Consultation Response from KC, Conservation and Design

2020/92546 Land off, Blackmoorfoot Road and Felks Street, Crosland Moor, Huddersfield, HD4 7AD

Date Responded: 3.11.20 Responding Officer: Sue Oakley Responding Ref:

1.18 ILLUSTRATIVE MASTERPLAN

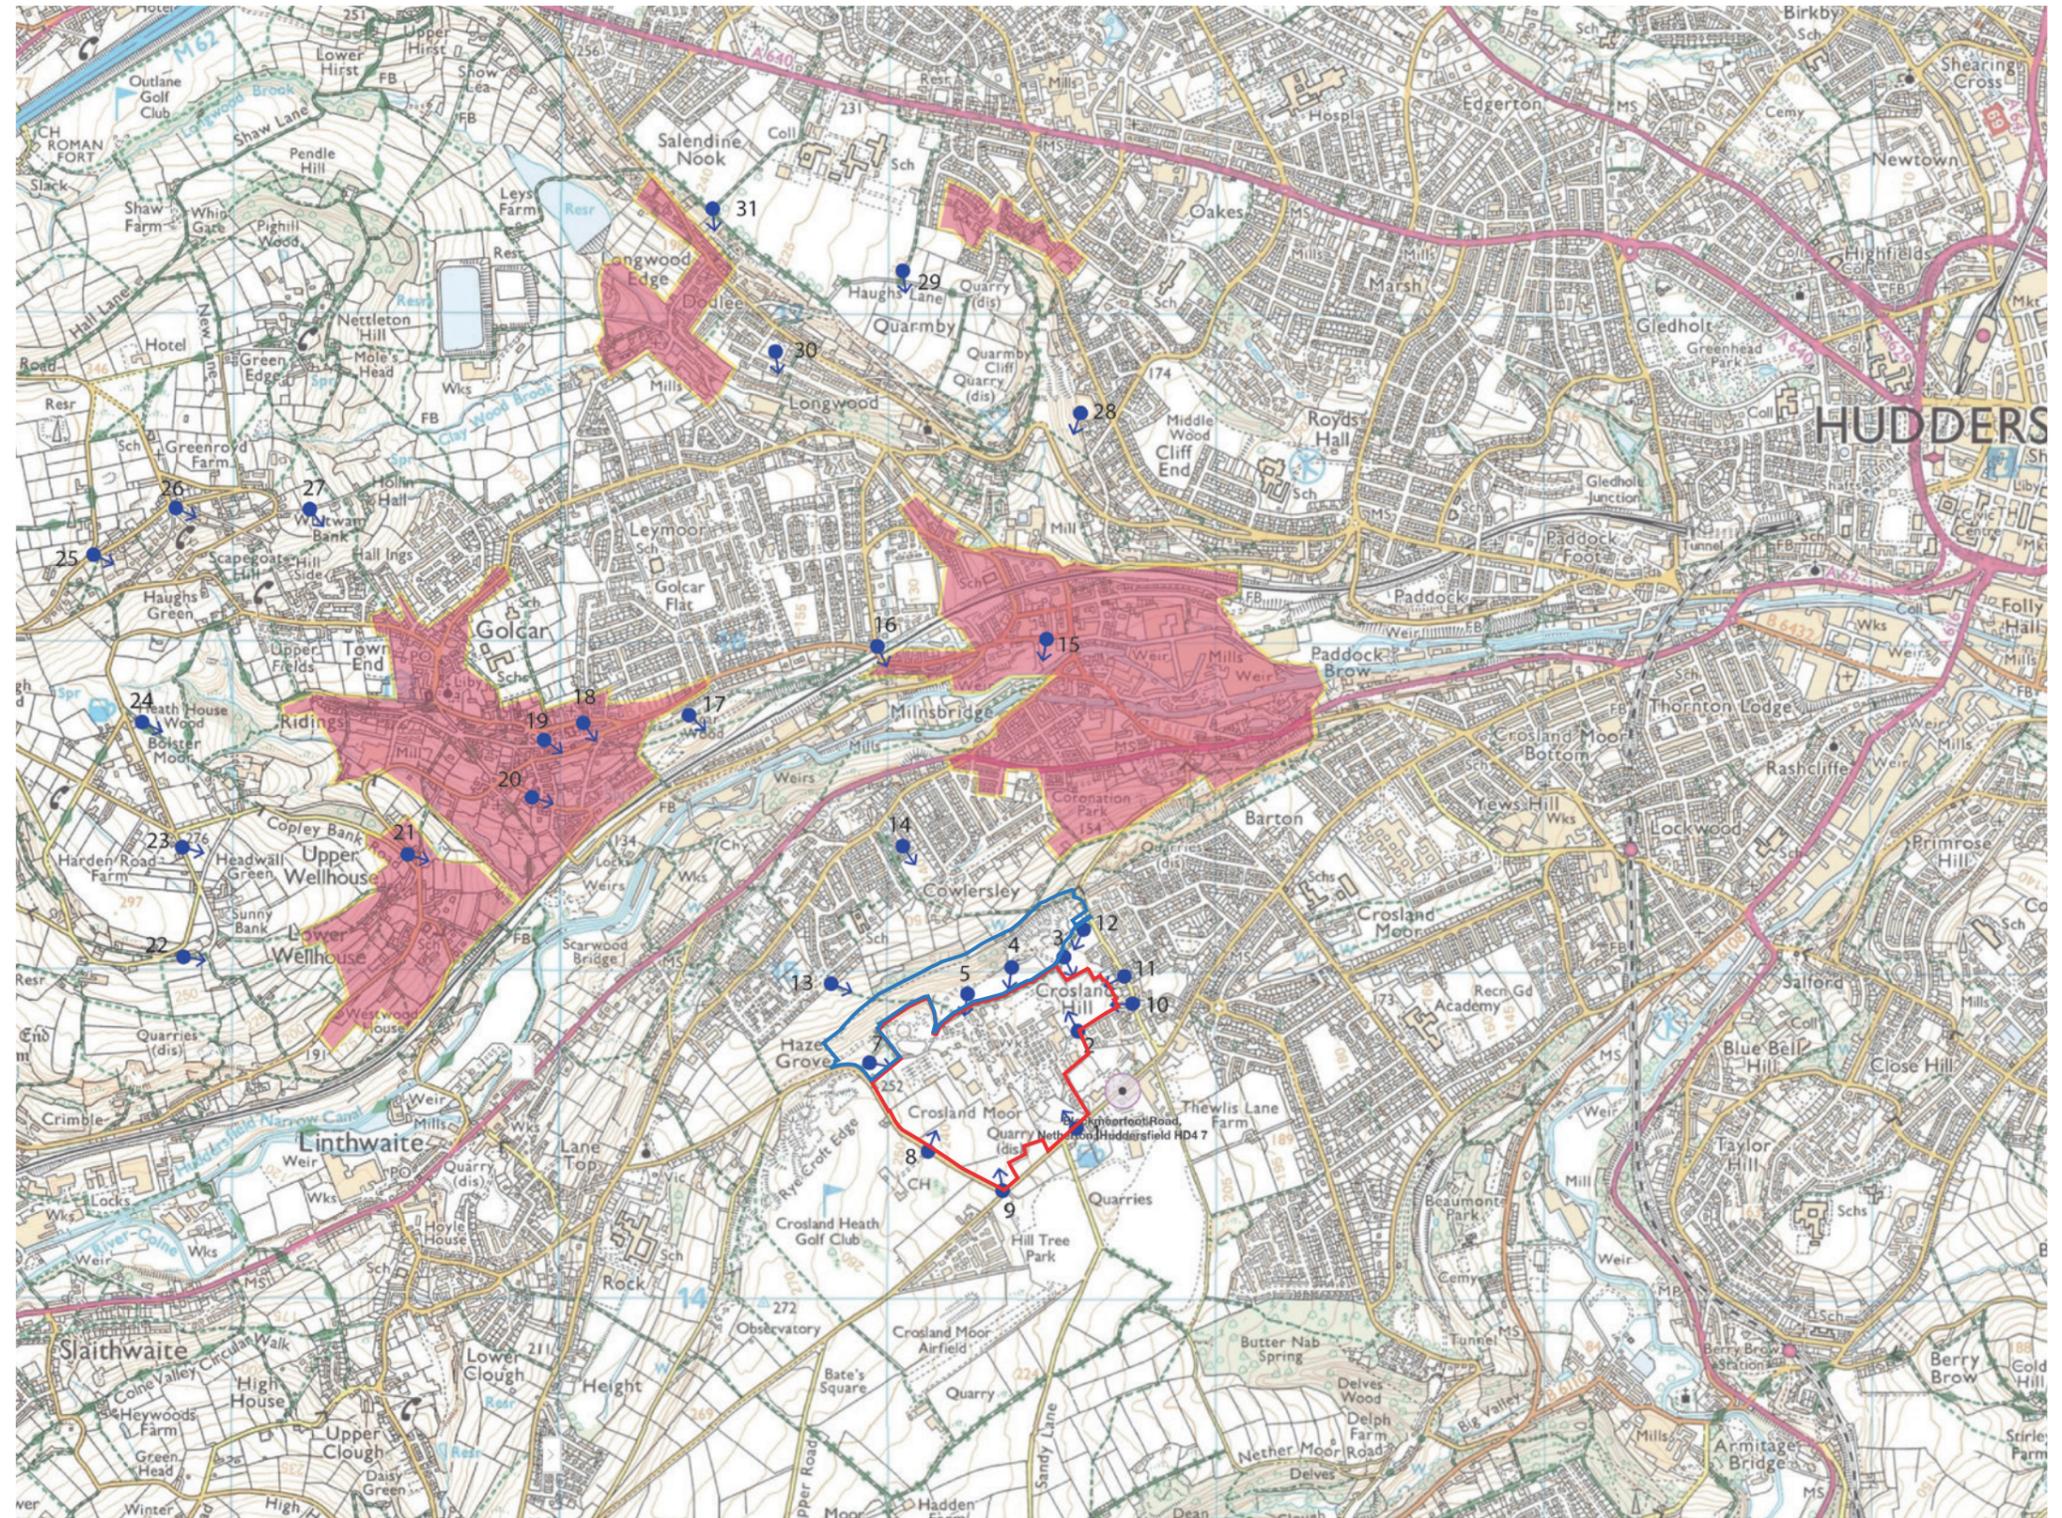
- Reflect the local characteristics including street layouts, scale and materials
- Provide a buffer between the development and Crosland Hill Road
- Retain the existing dry-stone walling boundary features
- Retain and convert the barn at Felks Stile
- Landscape an area of the site to the south east of Felks Stile to retain the views across the valley and rural context of this building

Although some distance away, the site affects the setting of Castle Hill which can be seen in the distance to the south east. A sensitively designed development of one and two storey dwellings is unlikely to harm its setting, or that of the nearby conservation areas, although the form of the development should reflect the local historic street patterns and local vernacular typical of the Colne Valley and views across the valley from Felks Stile Road should be retained. LP35 states that the general character of the towns and villages of Kirklees is typified by stone-built properties closely following the hillside contours and this should be considered so that the development sits comfortably within this landscape.

This structure is directly outside the north west boundary of the proposal site but within the blue line boundary, and its omission from the proposed block plan indicates that its demolition is proposed. Due to its early date and interest as a vernacular stone farm building, it has local interest and is considered to be a non-designated heritage asset. In addition, it is in a prominent location on the boundary of the site, particularly when viewed from the south east along Felks Stile Road. The Conservation and Design Team would welcome its restoration and retention and would recommend that it is incorporated into the proposal, with open landscaping retained along the south eastern boundary of the site to retain the view of this building and distant views across the valley. Again, dry-stone walling should be retained on this boundary.
